Engineers Comments Regarding Surface Water Drainage

Application Reference:	BN/64/26/PL	Reviewer Reference:	ADC/EXT5/AF
Planning Officer:	Amber Willard	Date of Review:	10/07/2026
Site Name:	Hill View Eastergate Lane Eastergate PO20 3SJ		
Application Description:	Demolition of existing dilapidated commercial sheds and the erection of 9 No dwellings and associated car parking and landscaping (resubmission following BN/83/25/PL). This application is a Departure from the Development Plan and is in CIL Zone 3 and is CIL Liable as new dwellings.		
Assessment Number:	1

Impermeable Area Assessment

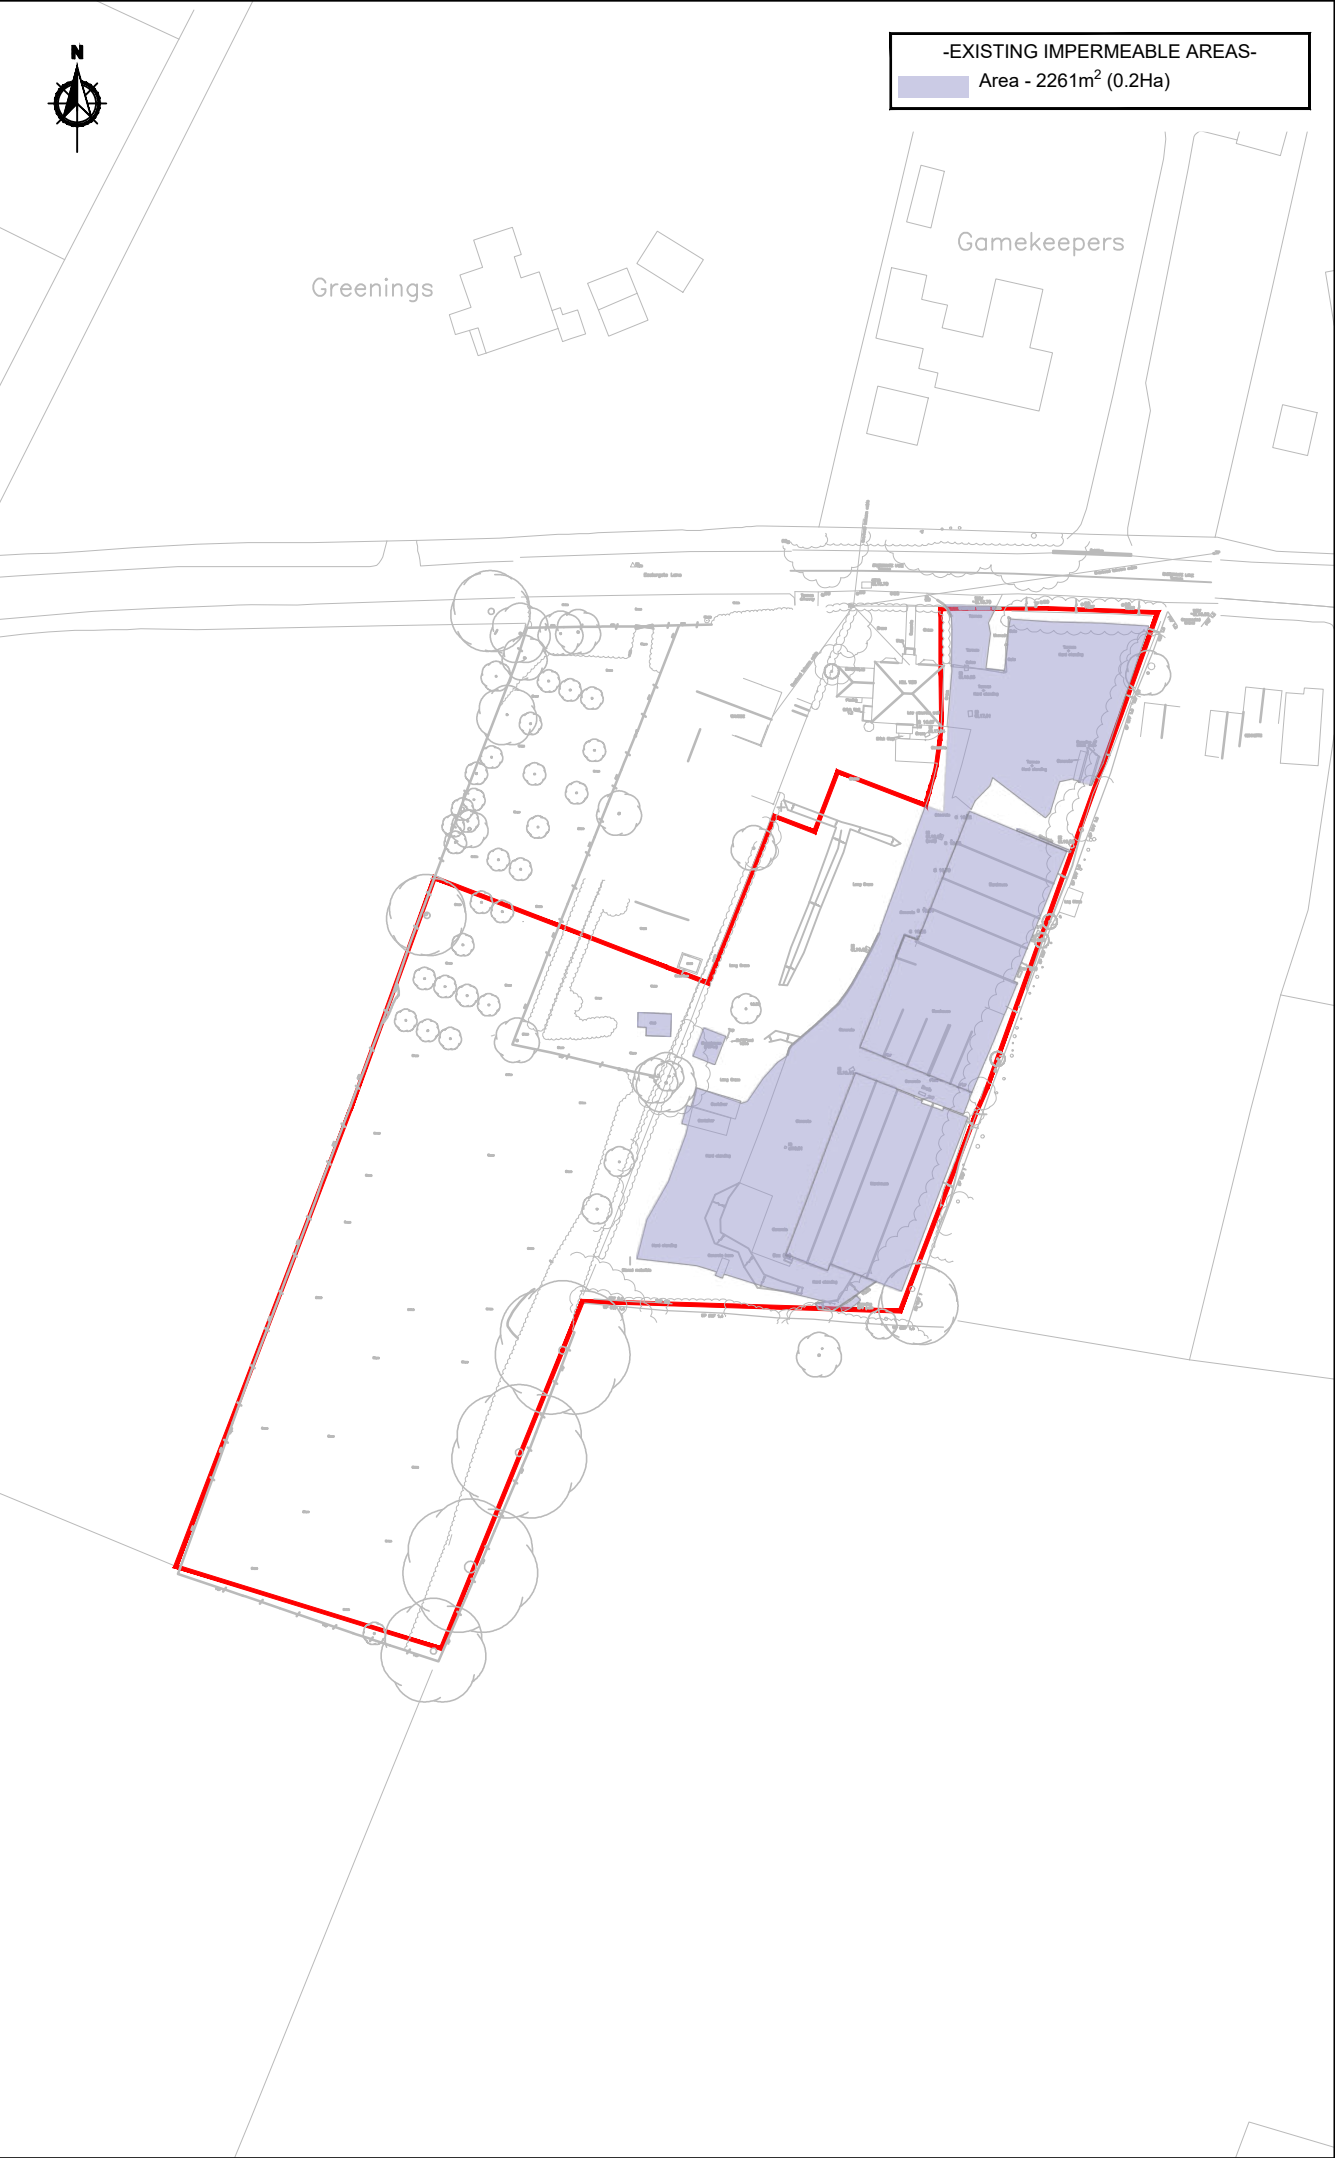
- 3.5. Root protection paving typically does not include a depth of stone storage in the same form as permeable paving. The drained areas and infiltration / attenuation of the root protection pavement needs to be included in the design and cannot be omitted.

Conceptual Drainage Strategy

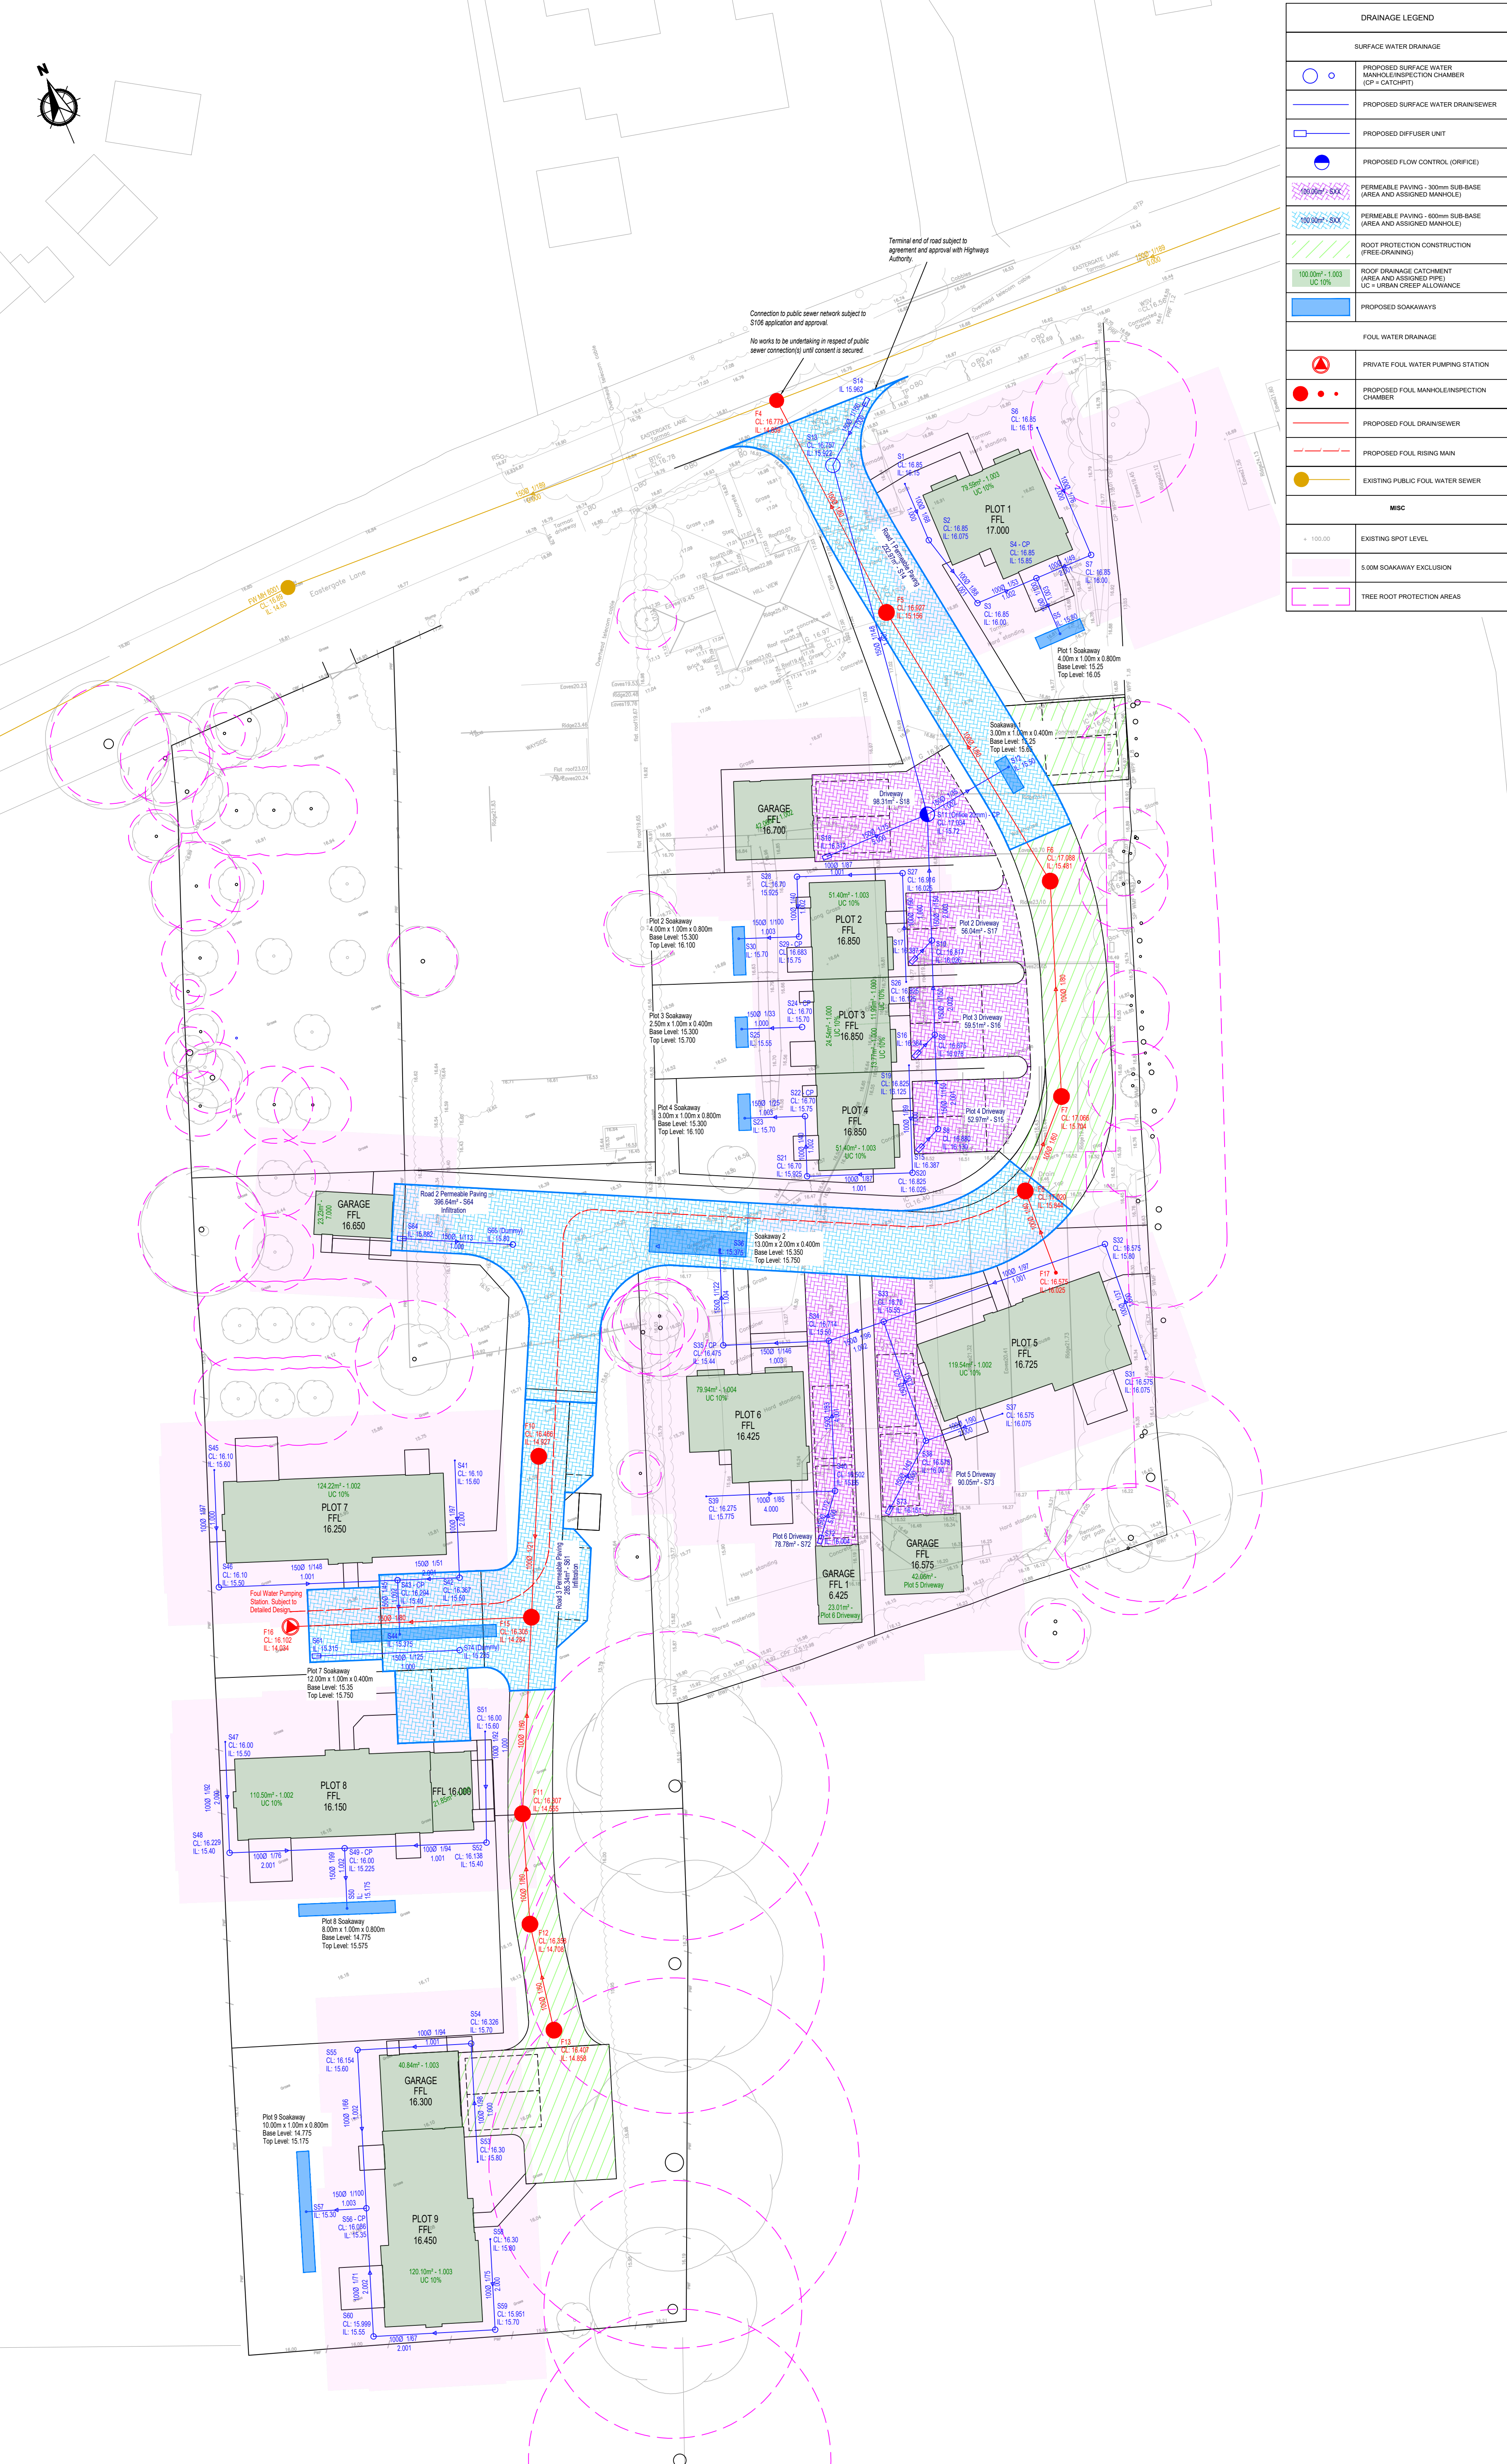
- 3.2. There may be a need to incorporate additional land drainage for overland flow identified by the surface water risk modelling and to prevent displaced floodwater. See General comments above. This should be identified in the design at planning stage to demonstrate the feasibility of the solution.

- 3.4. The letter report text states the permeable paving is modelled at a slope of 1:80 but we are unable to verify this from the calculations. The calculations do not clarify whether the permeable paving is modelled with a flat base of sloping base. Sloping infiltration blankets could overtop from the low end prior to filling. Base levels of constant depth to base should also be indicated on the drainage layout.
